# CITY OF ALBUQUERQUE

**RE: Sandia Area Federal Credit Union-Starbucks  
13101 Montgomery NE  
Requested for 30 Day Temporary C. O. - Accepted  
Engineers Stamp Date 7/1/15 (F22D002)**

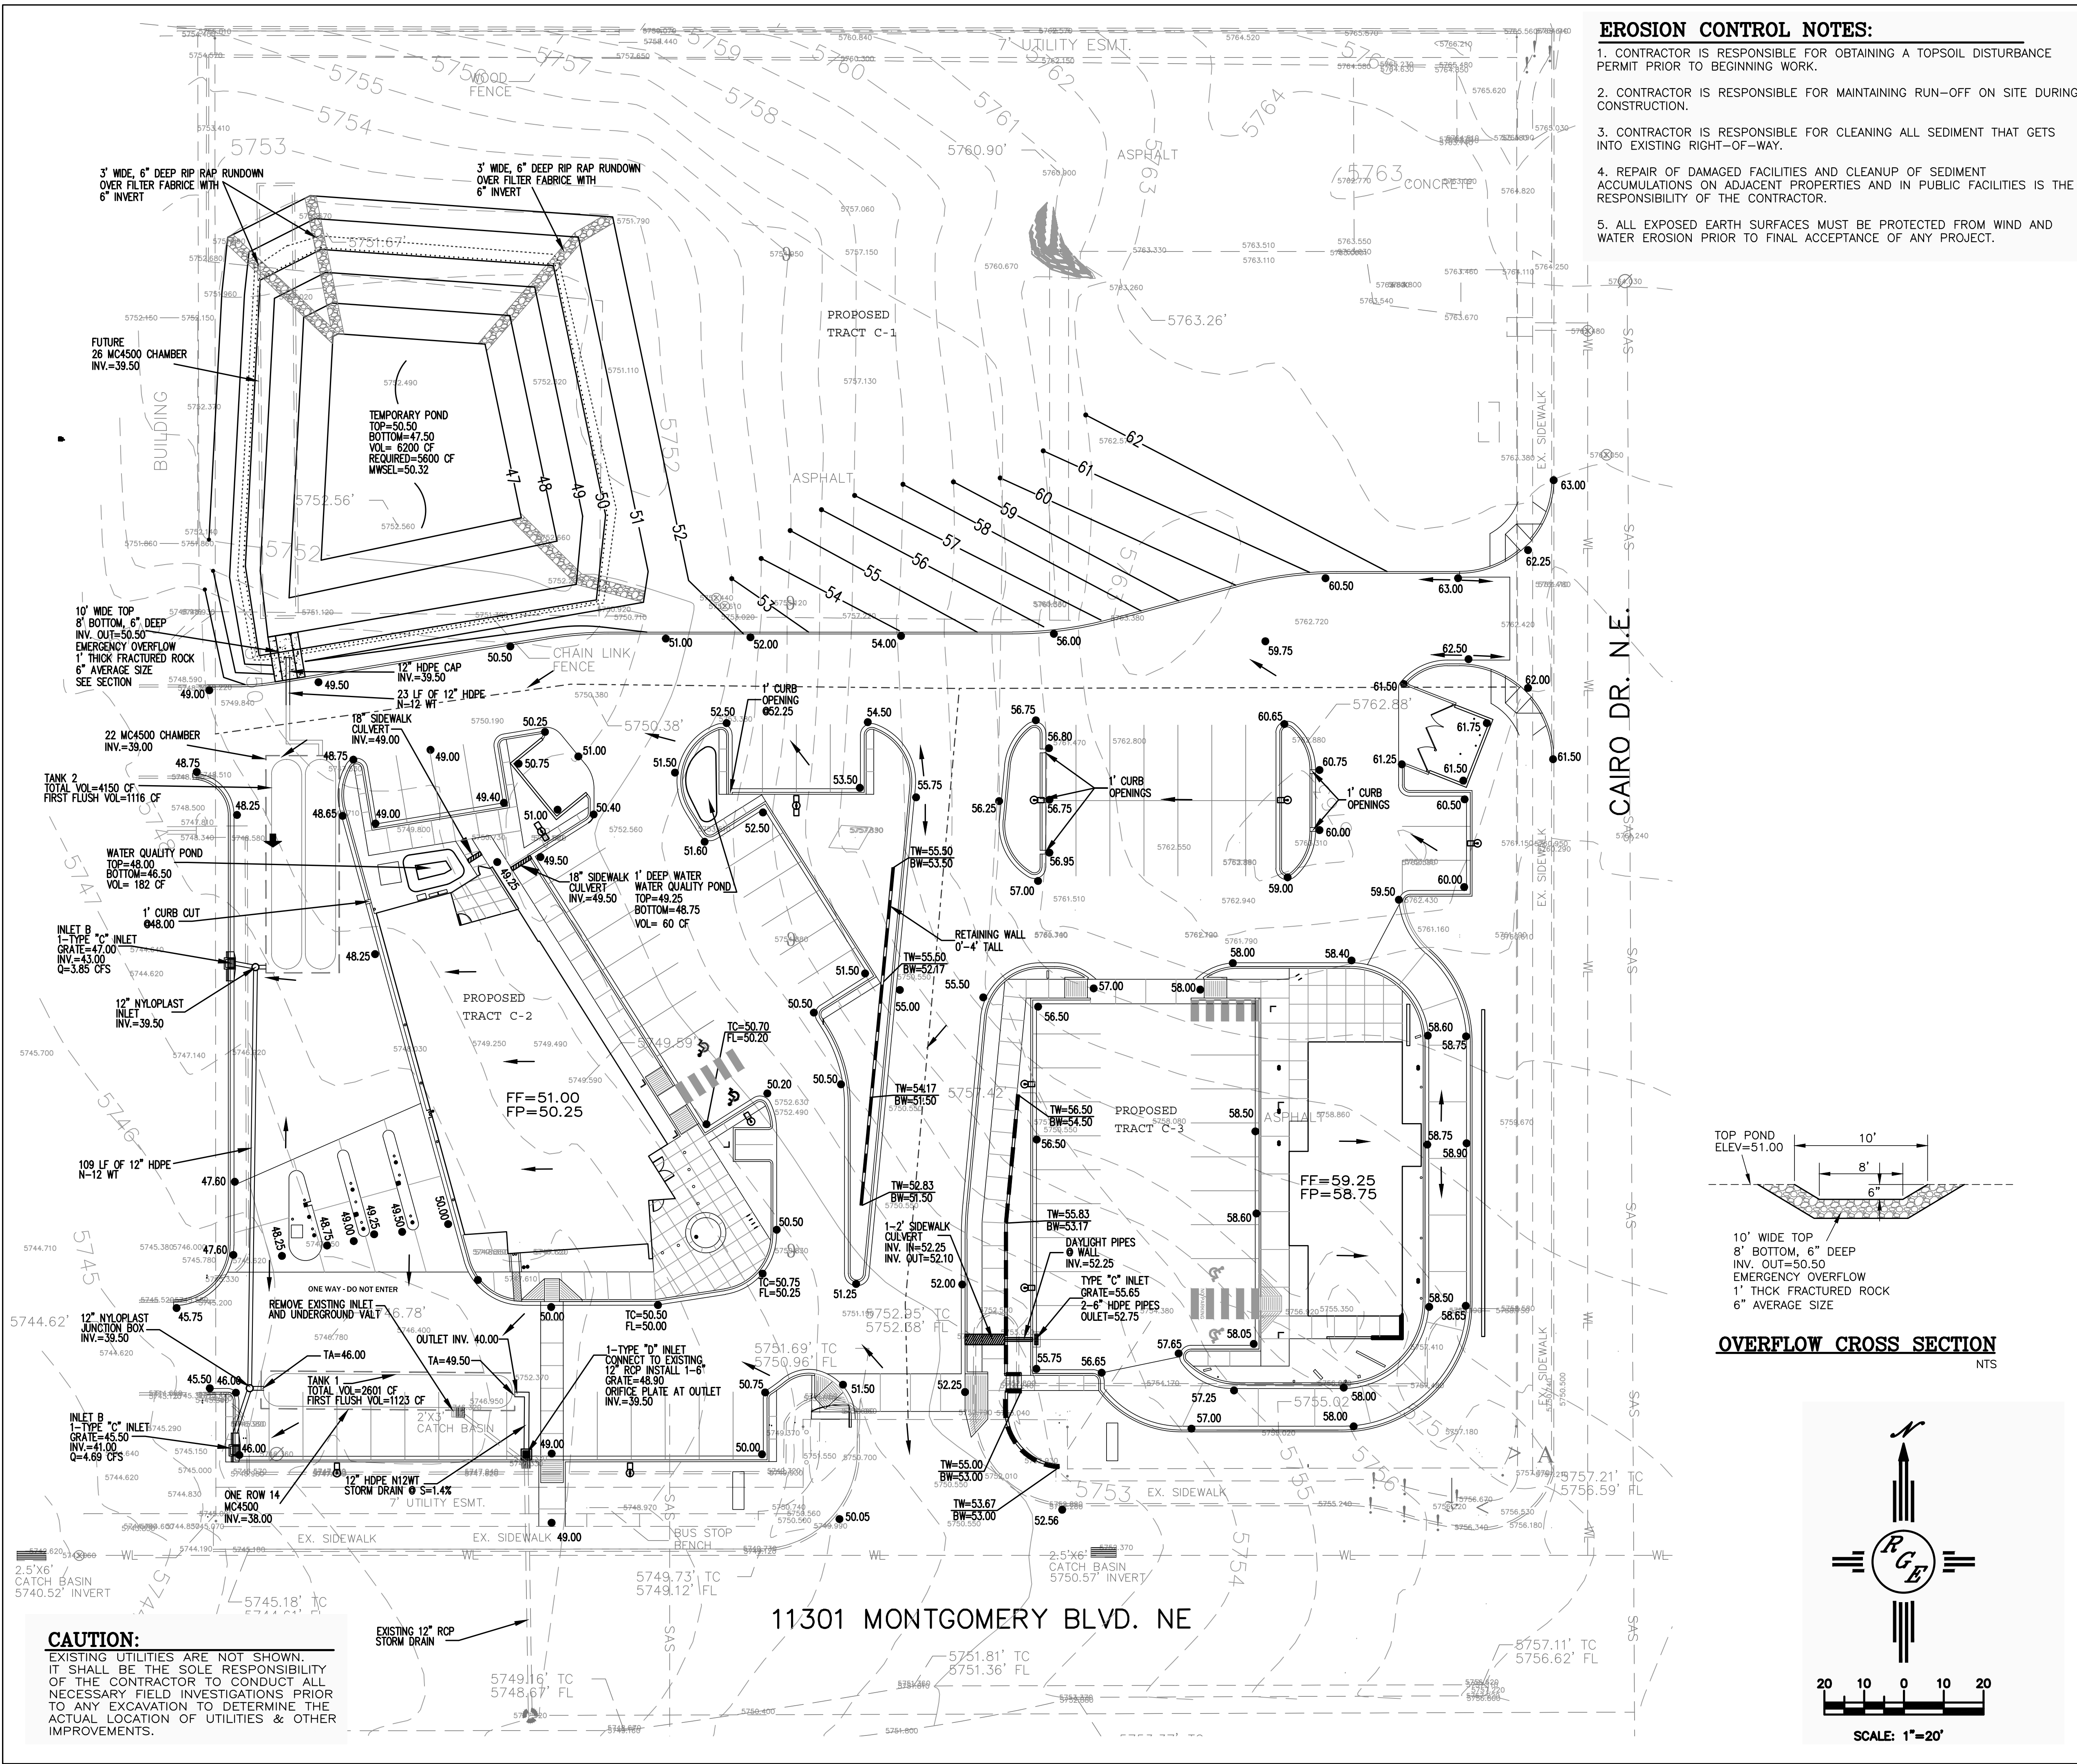
- The sidewalk culvert extends thru the First Flush Trench thereby blocking the flow. The sidewalk culvert must be cut back and stop at the edge of the sidewalk as shown on the approved drawing.
